Report: Road Safety Audit Stage 1**Report Title: New Highway Access, Barnham Road, Eastergate, West Sussex****RSA Team: M.B.Projects Ltd****Date: June 2021****RESPONSE REPORT**

Report: Road Safety Audit Stage 1
Report Title: New Highway Access, Barnham Road, Eastergate, West Sussex
RSA Team: M.B.Projects Ltd Date: June 2021

Organisation: Motion Consultants Limited	Organisation: West Sussex County Council
Date: 29 th June 2021	Date:

Project: The Croft Medical Centre		
Title: Proposed Access Arrangement and Visibility Splays		
Scale: 1:250 (@ A3)		
Notes:		Revision: A
Drawing: 2011094-01

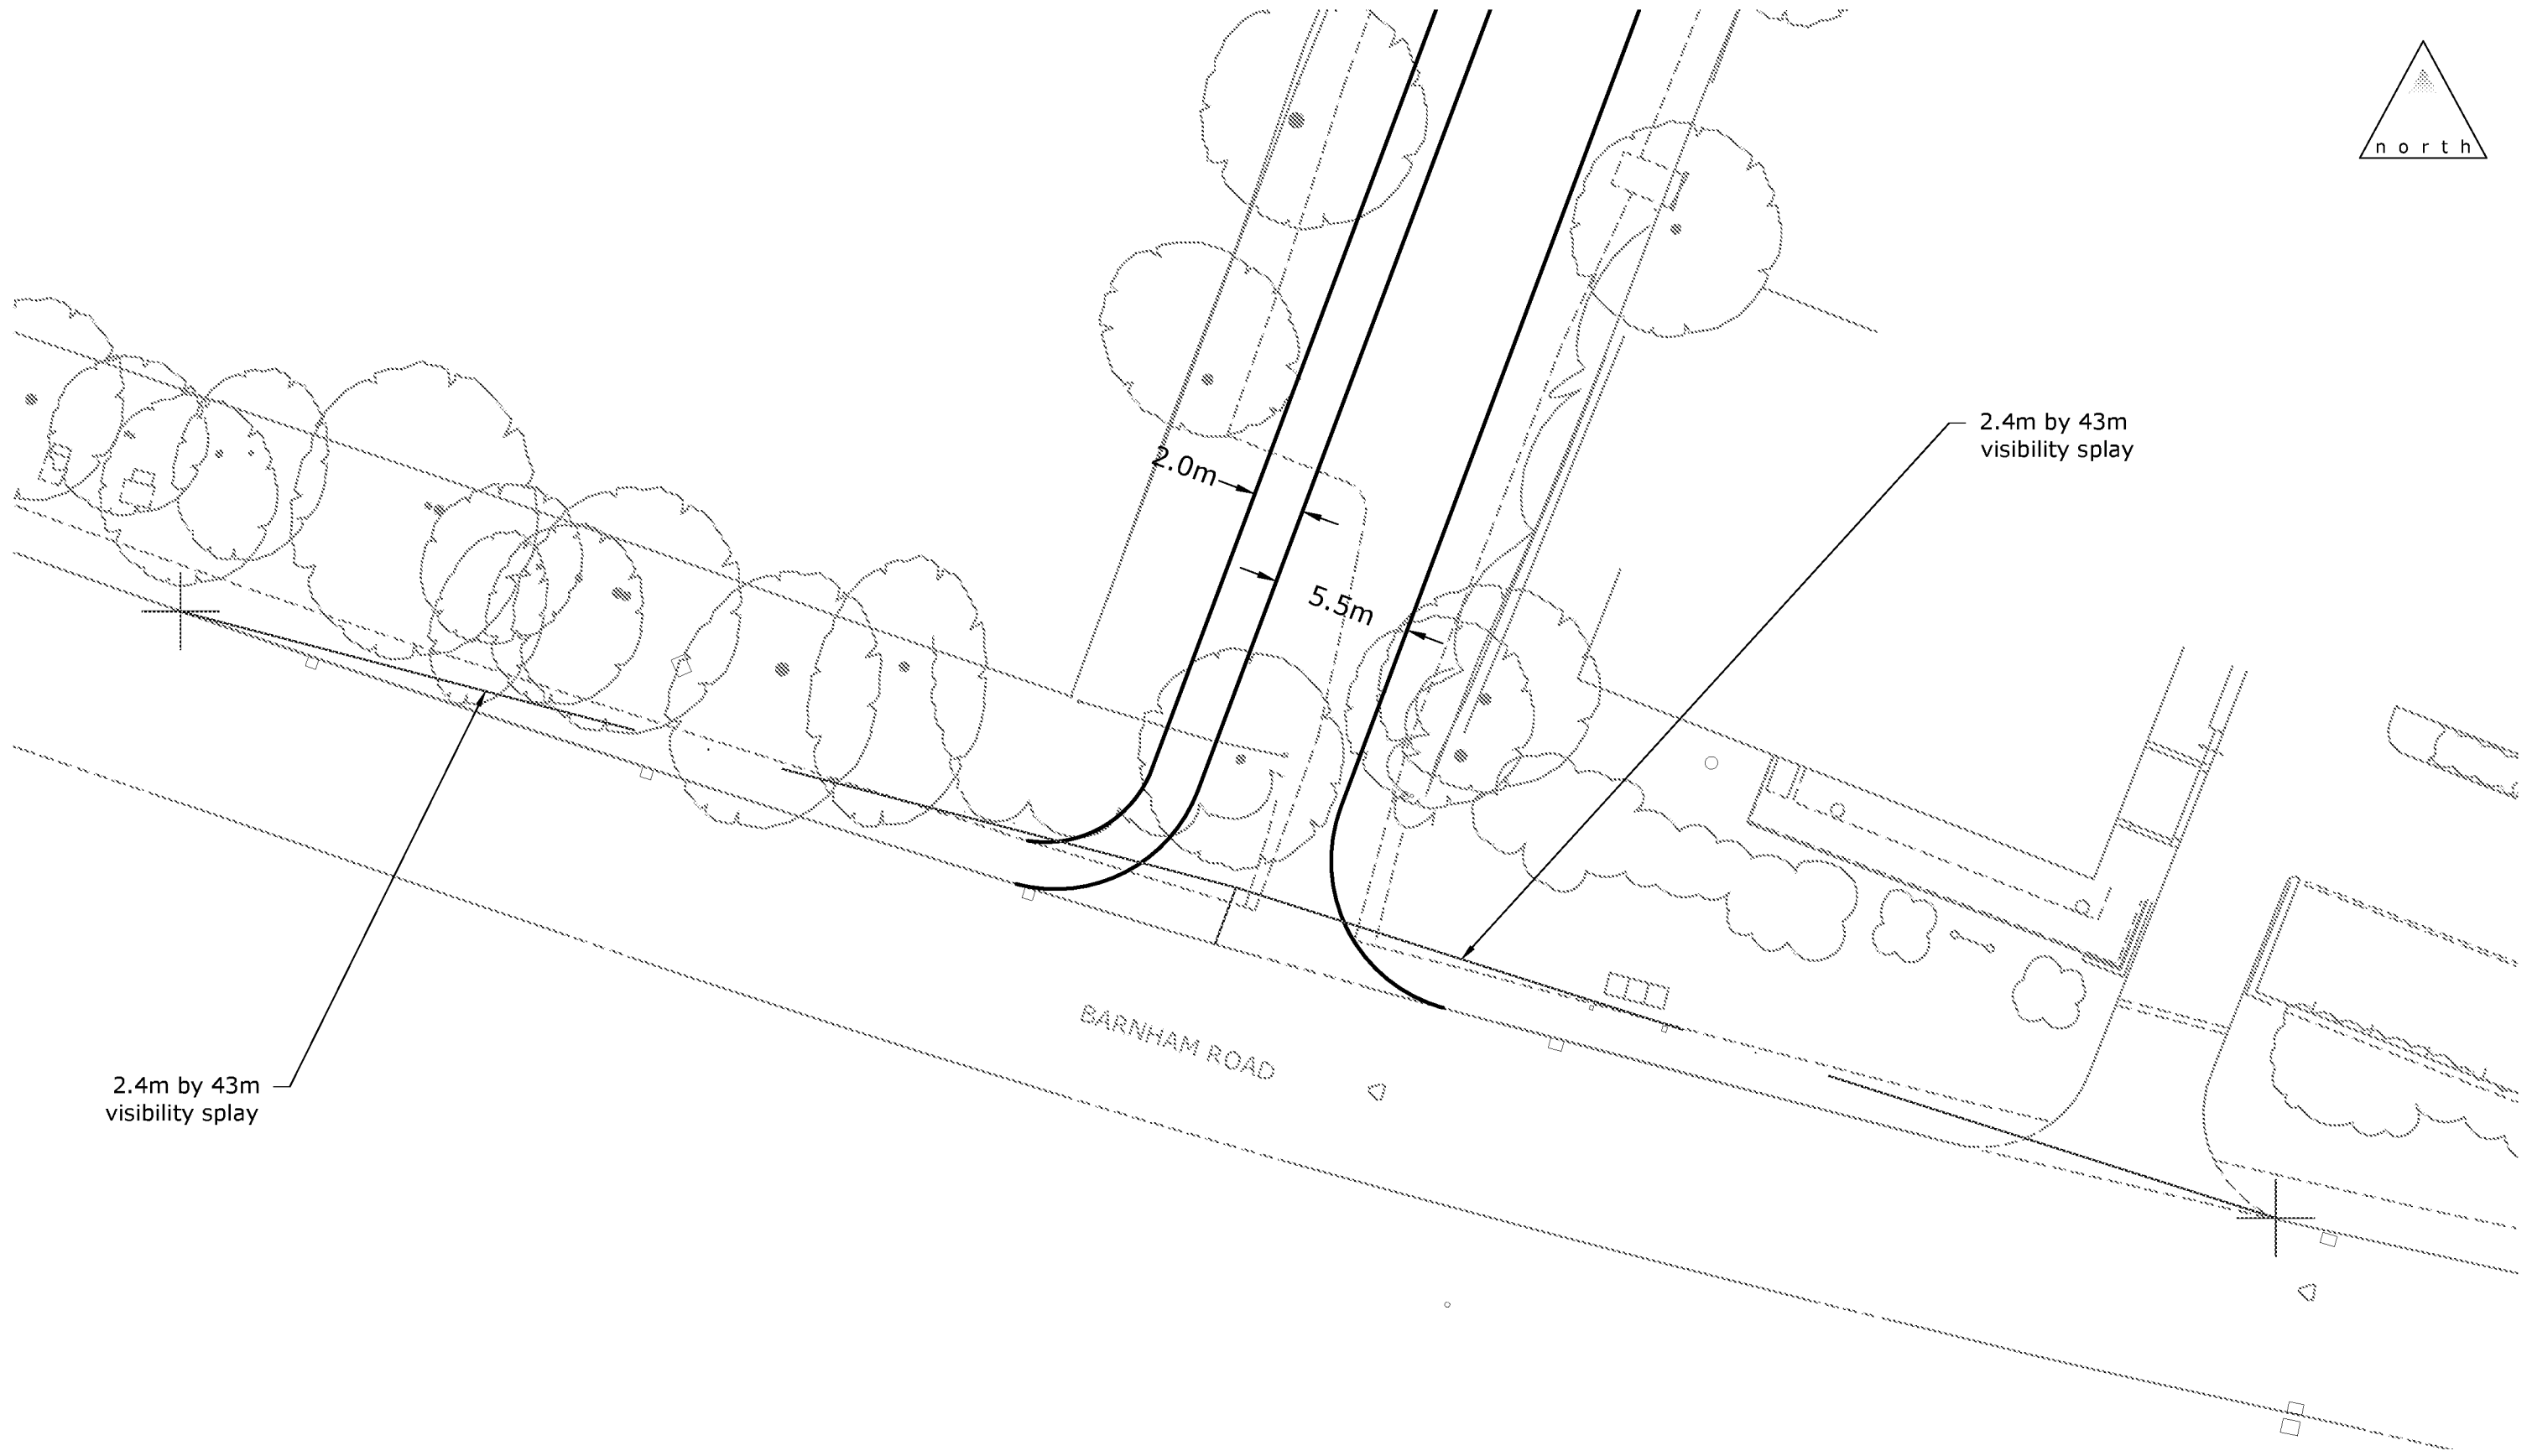
RSA Problem	RSA Recommendation	Design Organisation Response	Overseeing Organisation Response	Agreed RSA Action
2.3.1 It was observed that the existing unmade access road slopes down to Barnham Road. A future side road slope could result in vehicles rolling forward into the path of southbound vehicles on Barnham Road and collision occurring	The detailed design includes a flattish section of access road to the give way line to reduce the risk of roll forward incidents	This comment is noted. The detailed design of the revised access junction will include a flatter section to avoid the issue raised.

2.4.1 It was observed that there is a northbound bus-stop located a short distance to the south of the proposed access, but no existing crossing point for visitors to the Medical Centre to cross Barnham Road. There is a risk of pedestrians crossing from unsafe locations, or where there is a full height kerb upstand risking trip or fall	The Designer reviews the need for a formal dropped kerb crossing point between the access and the bus stop to assist pedestrian movement/desire lines.	The revised access junction arrangement shown on Drawing SK01 Revision C illustrates a dropped kerb crossing point located between the access and the bus stop. This could be dealt with via any Section 278 agreement for the access works.

2.4.2 The northbound bus stop could be used by visitors to the Surgery. At present there is no hardstanding at the bus stop which is located within a verge area. Concern arises that a passenger could slip on wet grass while getting on or off the bus, risking personal injury	A hard standing area should be provided across the verge at the bus stop to assist bus passengers to get on and off the bus	Drawing SK01 Revision C illustrates an indicative area of hardstanding on the exiting verge to aid passengers departing the bus. This could also be implemented via the Section 278 agreement.
